Subject: Copi Mineral Sands Mine (SSD-41294067)

Thank you for your email dated 16 May 2024 seeking advice from the Biodiversity, Conservation and Science Group (BCS) of the NSW Department of Climate Change, Energy, the Environment and Water about the Environmental Impact Statement (EIS) for SSD-41294067, Copi Mineral Sands Mine.

ATTACHMENT A – BCS Assessment Summary and Recommendations for Copi Mineral Sands Mine Environmental Impact Statement (SSD 41294067)

Figure 1: SAII Impacts for *Austrostipa nullanulla*

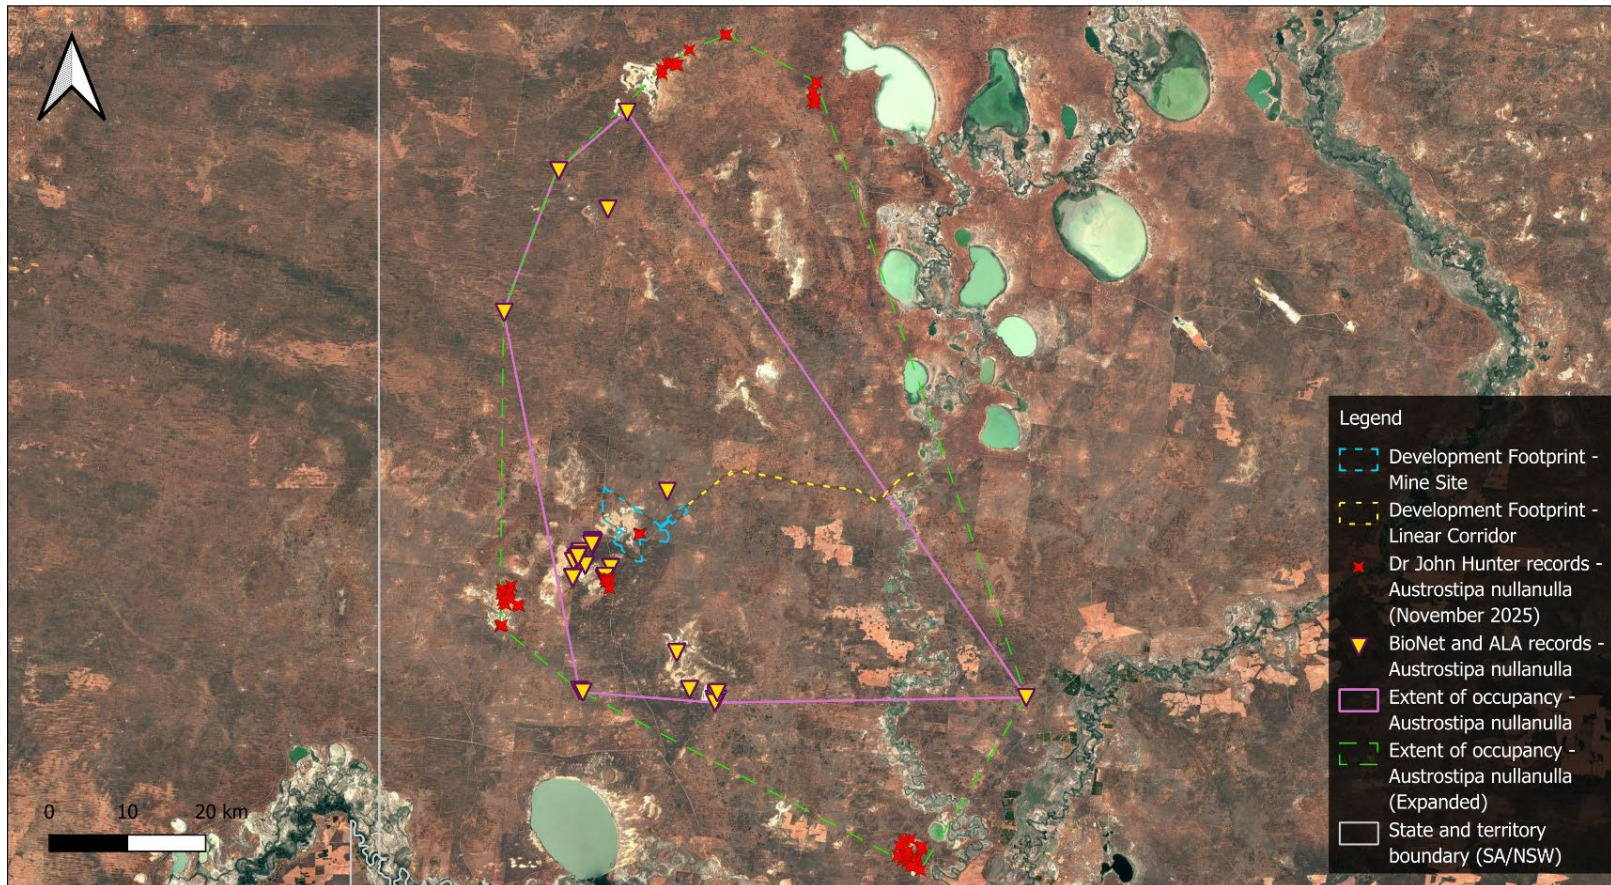
5. The *Austrostipa nullanulla* species polygon needs to be revised

Austrostipa nullanulla is an 'area' candidate flora species. In accordance with s5.2.5(4(b)) of the BAM, the species polygon for 'area' species must be mapped to the extent of the vegetation zone where there are no habitat constraints. The species polygon in the BDAR for *Austrostipa nullanulla* has not been mapped to the extent of PCT 253, and as such it does not comply with the BAM.

The BDAR provides no additional method or justification for why the species is not mapped to the extent of the vegetation zone even though there is a separate spatial data file called 'Copi_AustrostipaNullaNulla_PotHabitat' that maps potential habitat for the species and includes larger areas to the extent of PCT 253. There are other areas of PCT 253 that have not been surveyed (BDAR Figure 51 and 52) and are not included in the *Austrostipa nullanulla* species polygon.
